**RE: GWANDALAN RESIDENTIAL SUBDIVISION PROJECT APPLICATION (MP10-0205) –  
REVIEW OF ENVIRONMENTAL ASSESSMENT**

### **Department of Environment, Climate Change and Water – Review of Environmental Assessment (EA) for Gwandalan Residential Subdivision (MP10-0205)**

Plan of: Proposed Subdivision of Lot 3 DP 588206

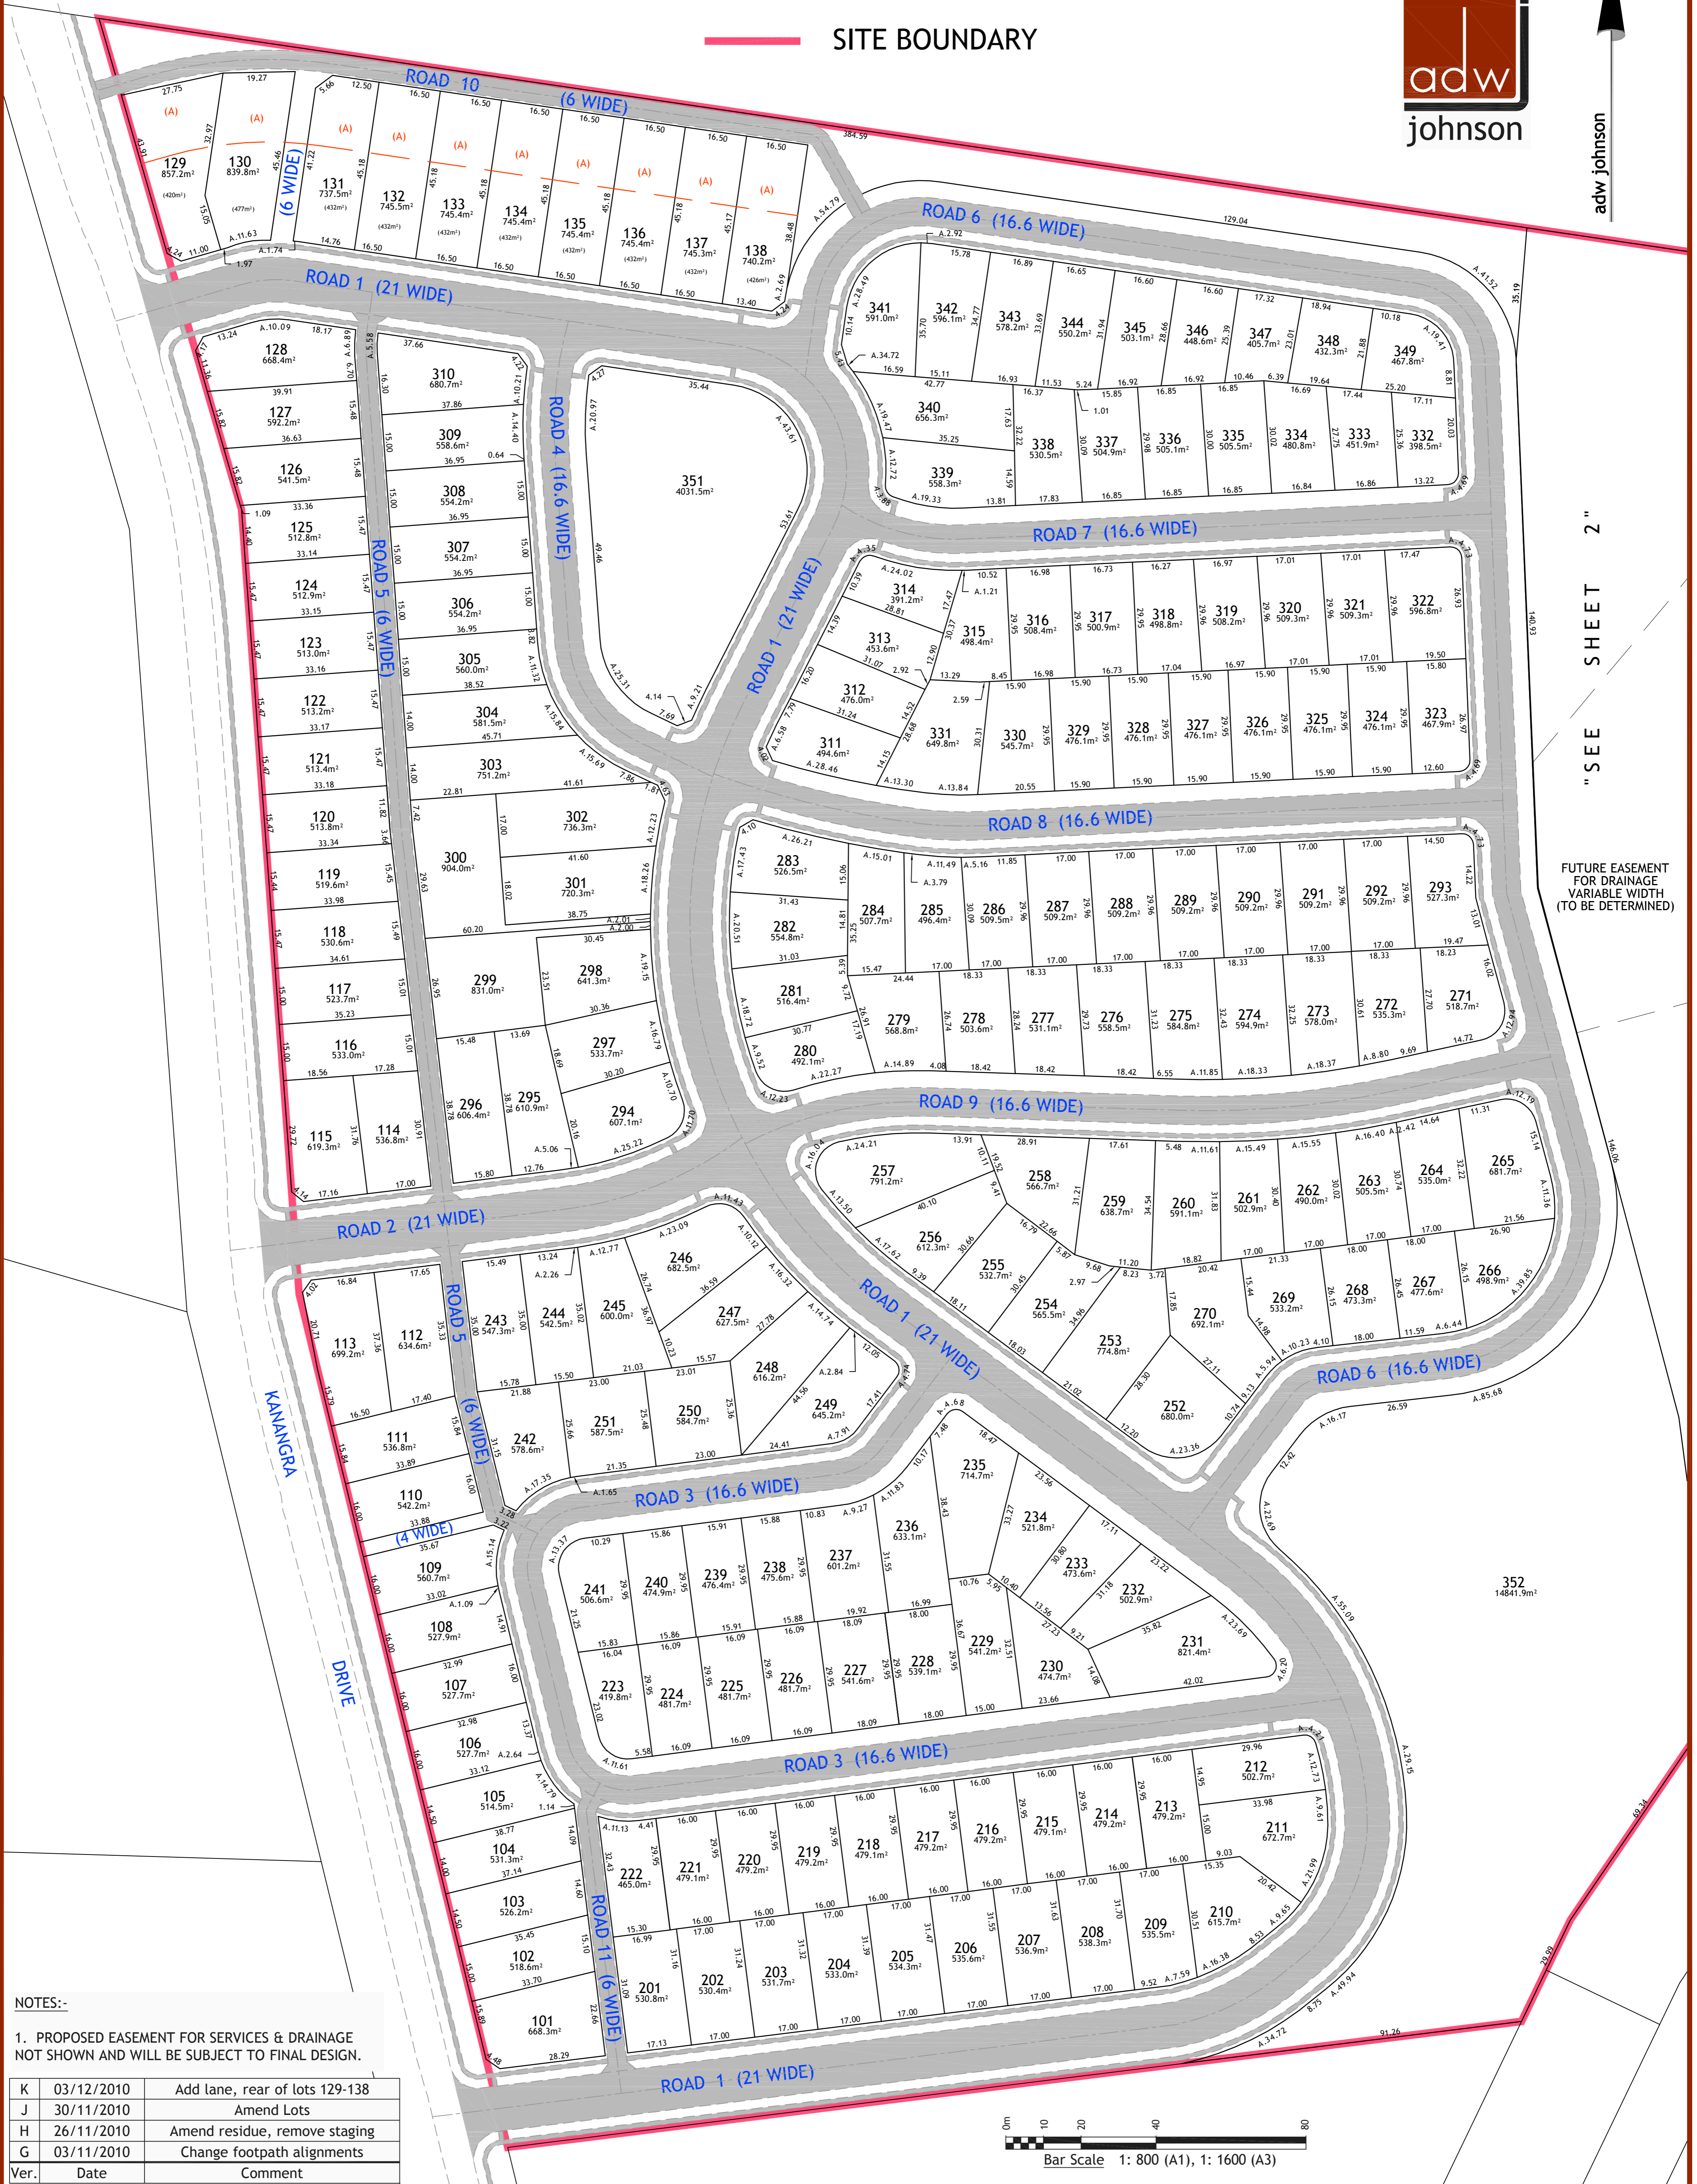
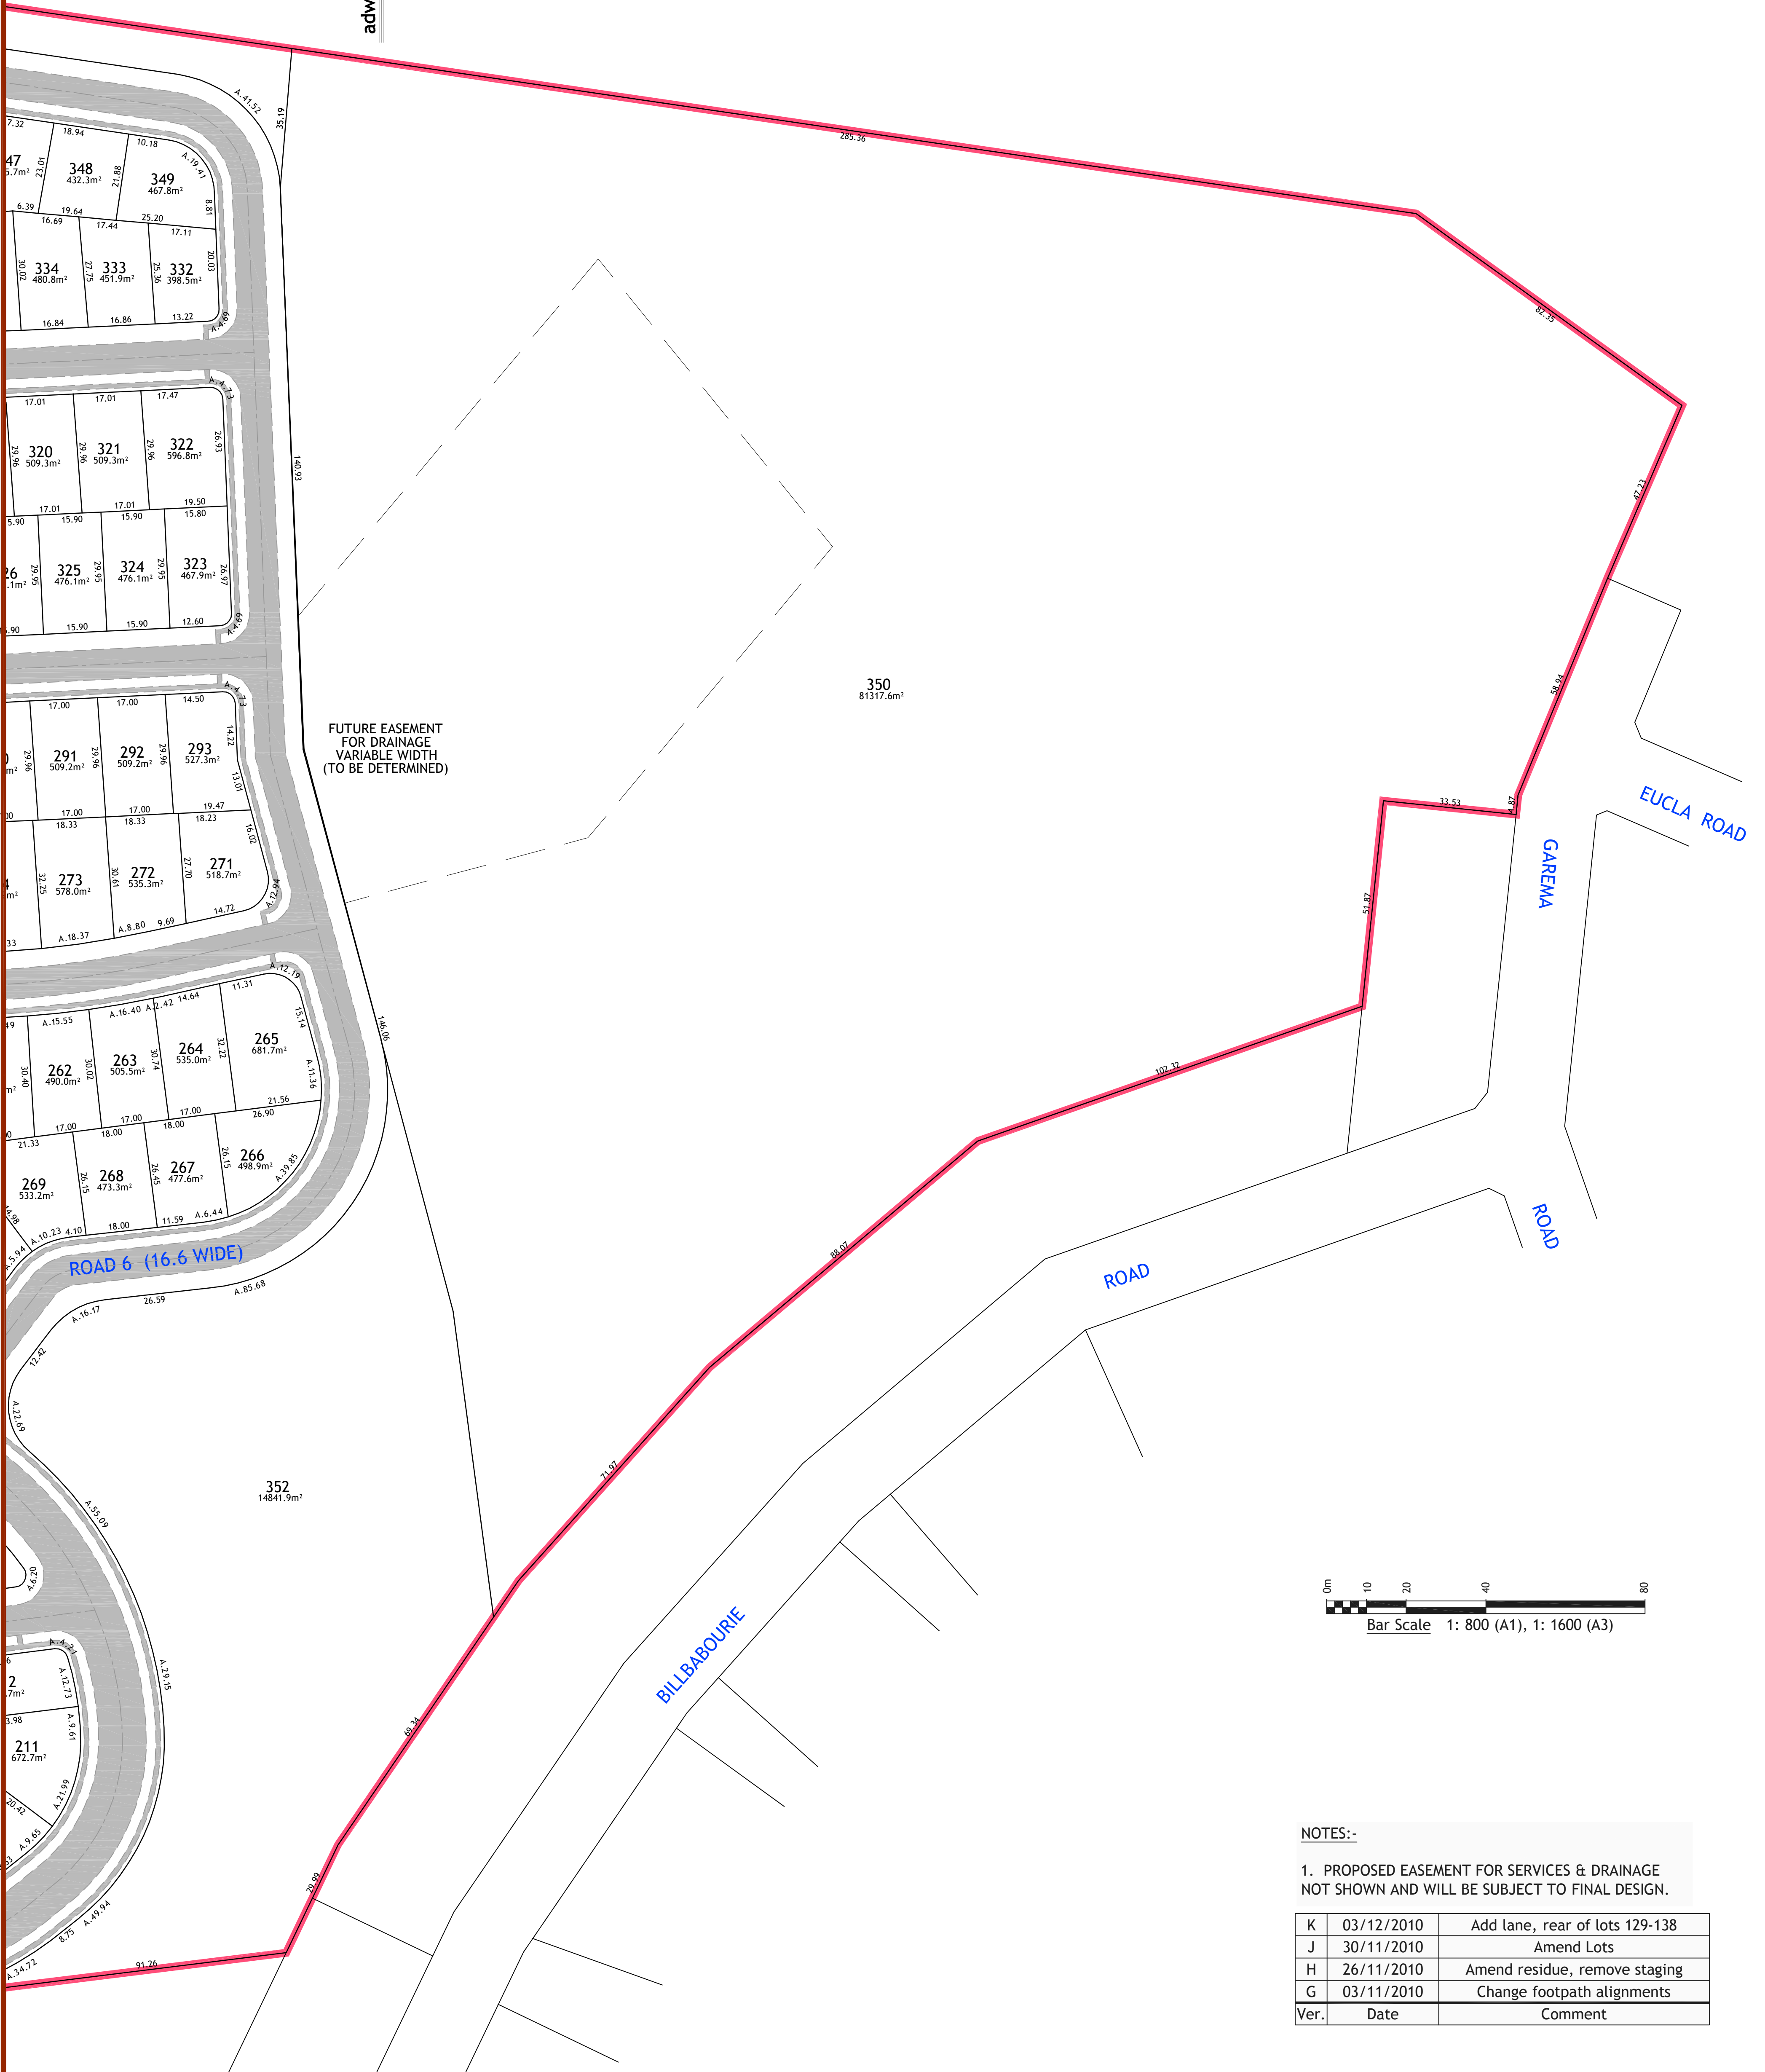
DECCW reconfirms that all asset protection zones should be fully contained within the development area and should not be dependent on management activities within Lake Macquarie SCA. It is also requested that further information be provided on the proposed boundary definition / fencing material to Lake Macquarie SCA. The boundary to the reserve should be clearly defined in this location to minimize issues from boundary encroachment (rubbish dumping, etc). The proponent should contact DECCW's Parks and Wildlife Group to determine the preferred fencing material to be used.
